**City of Portland, Maine - Building or Use Permit Application**

Permit No: 04-0267	Issue Date: MAR 30 2004	CBL: 092 B002001
-----------------------	----------------------------	---------------------

Location of Construction: 549 Island Ave	Owner Name: Friedman Marian T & Etals Jts	Owner Address: 401 Cumberland Ave # 1406	Phone:
Business Name:	Contractor Name: no contractor / self	Contractor Address: Portland	Phone:
Lessee/Buyer's Name	Phone:	Permit Type: Garages - Detached	Zone: IR-2

Past Use: single family	Proposed Use: single family - build 18' x 24' storage shed	Permit Fee: \$201.00	Cost of Work: \$20,000.00	CEO District: 1
Proposed Project Description: build 18' x 24' storage shed		FIRE DEPT: N/A	INSPECTION: Use Group: U Type SB BOLA 1999	
		Signature:	Signature:

FLOOR FRAMING

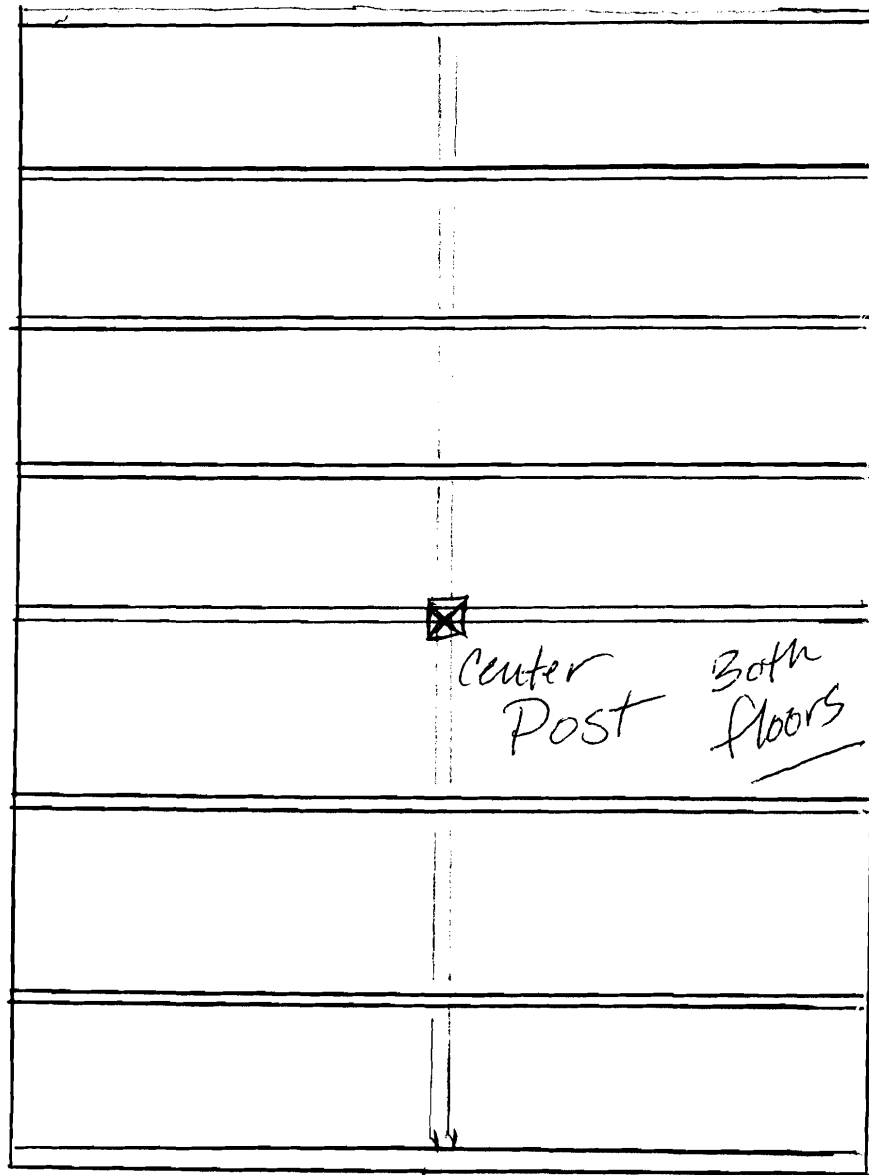
- 1) The structure is approved as a storage shed. It is NOT approved as a detached garage due to the structural design and the combustible floor system.

3/18/04-tmm: Hold - need engineered design on floor system - wants to have daylight and space below - proposed a wood floor system and needs to be noncombustible.

3/30/04-tmm: Changed to a stora
